Ref: 84 Langbury Lane, Ferring. Ref: FG/131/17/HH

Please find enclosed two copies of our plan for the extension at the above, which has been amended to our client's requirements.

Plan 1:50

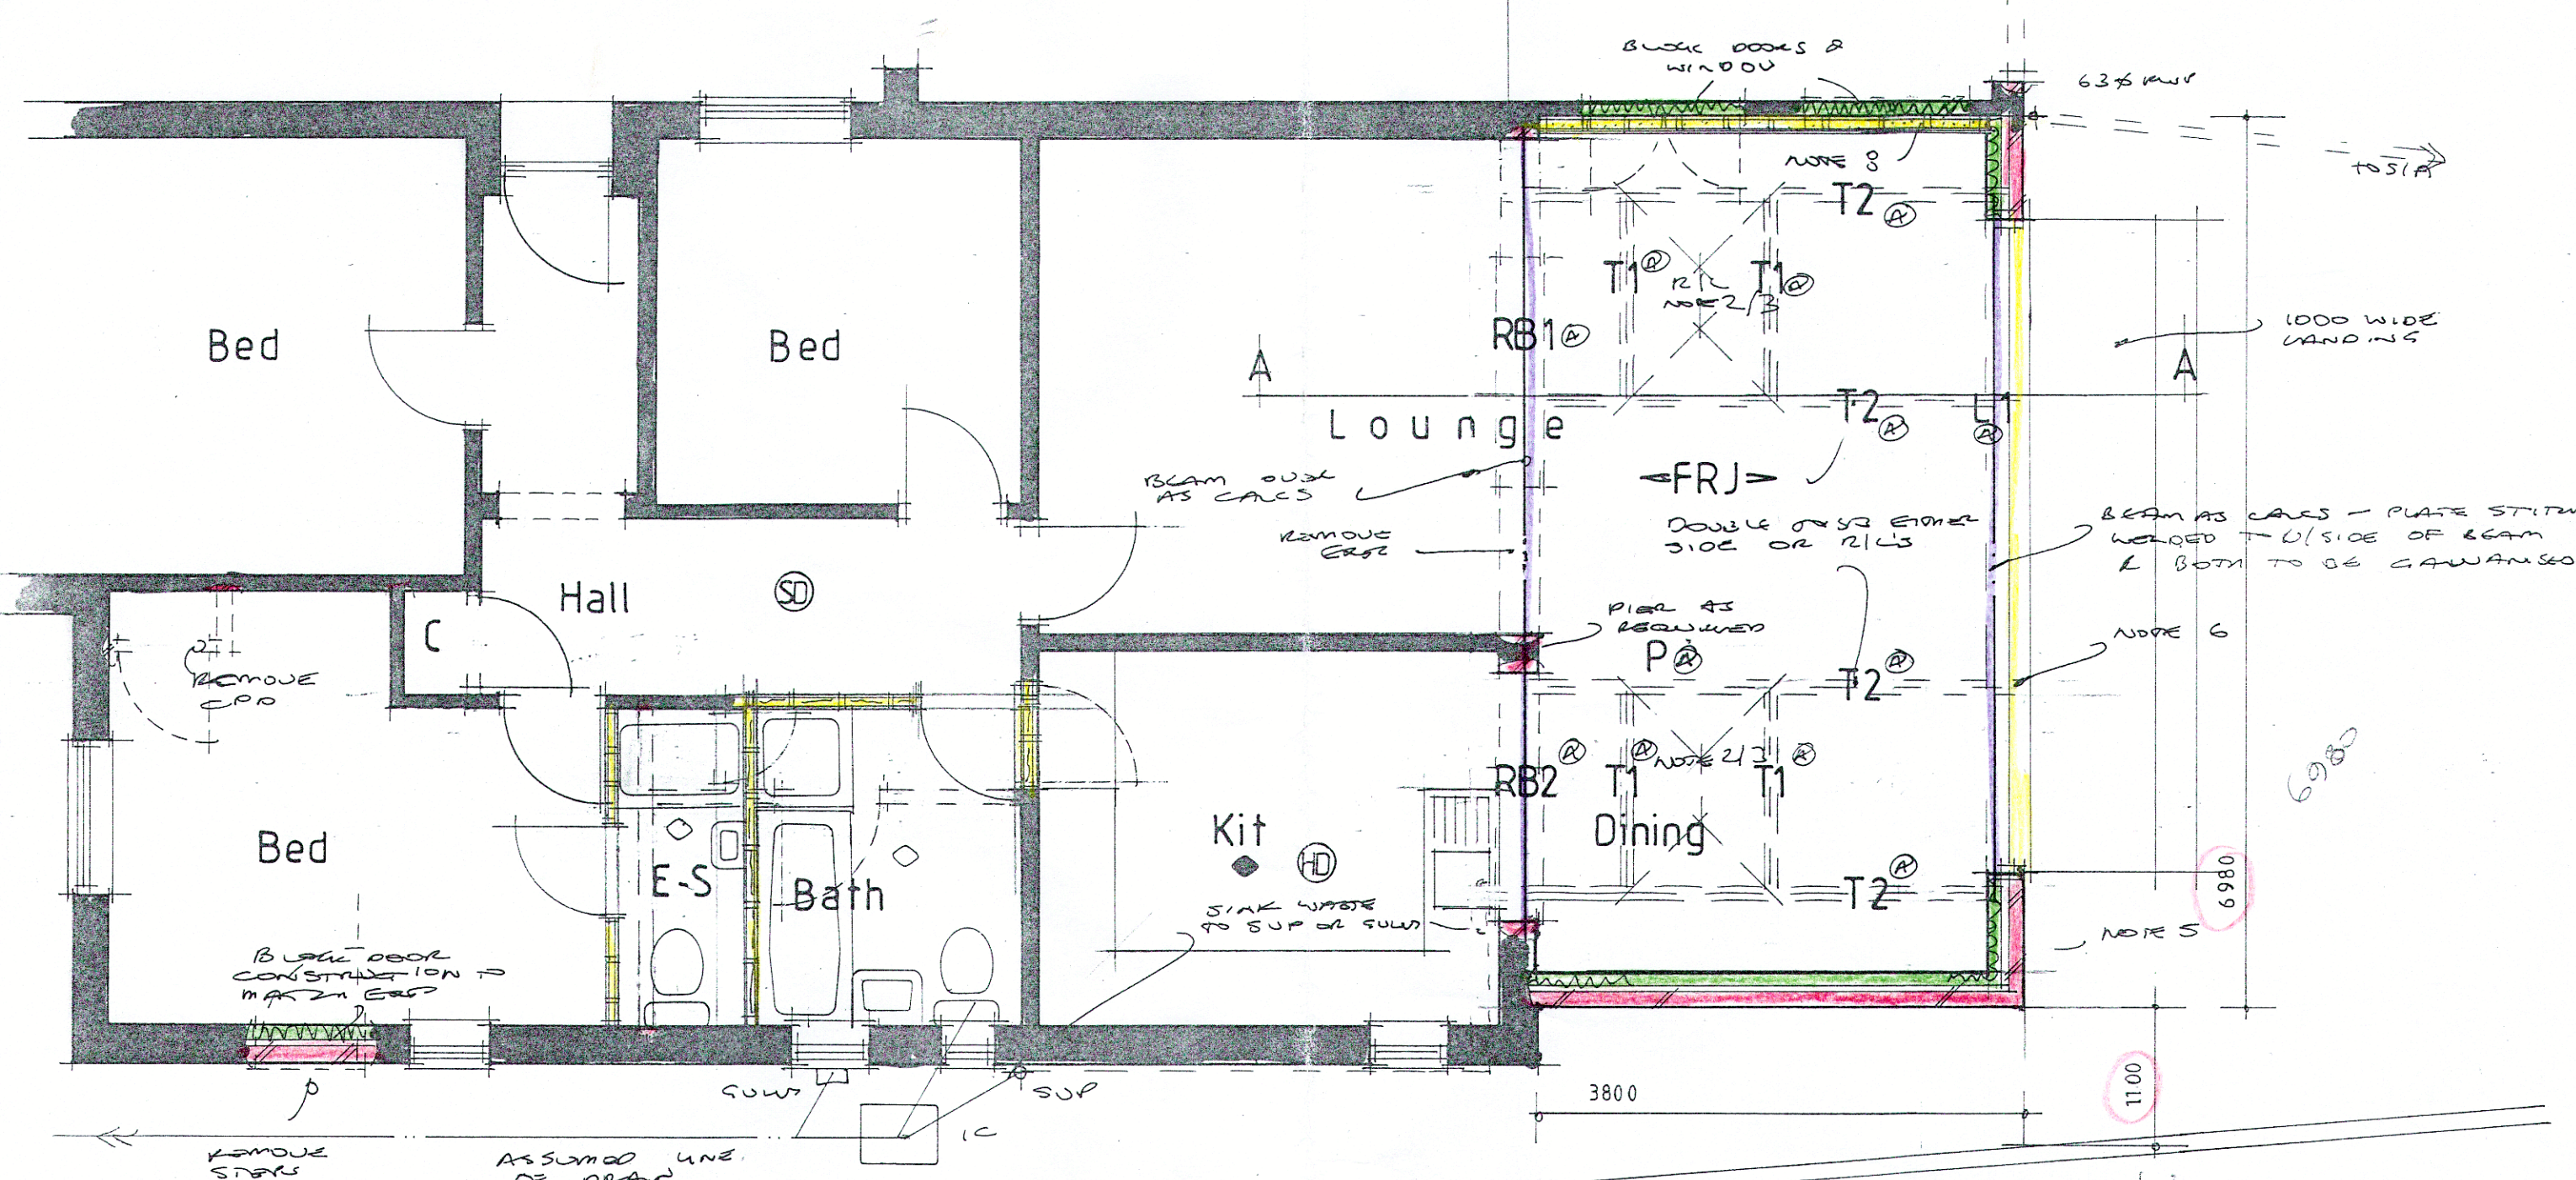
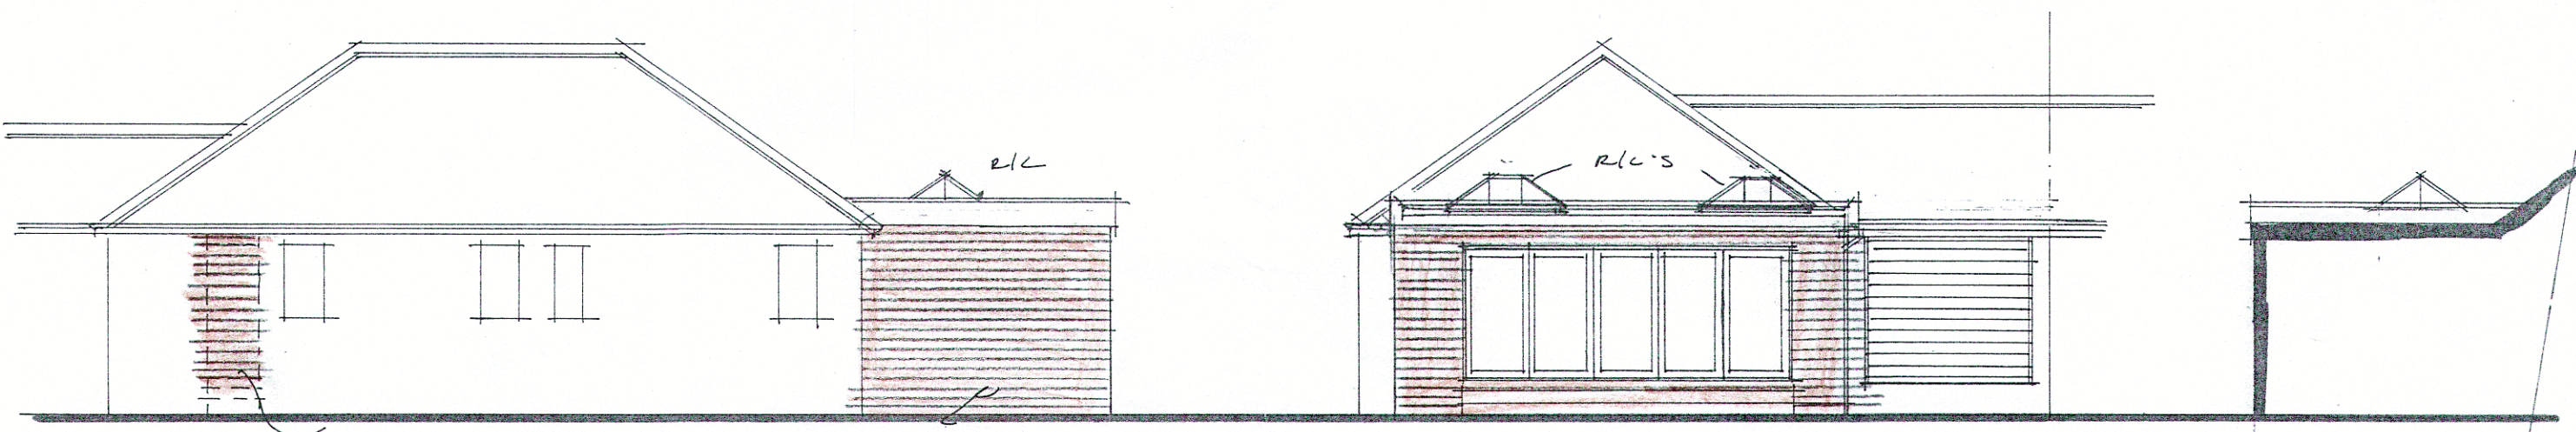
The extension has been increased to 6.98m wide and 1.1m from the boundary.
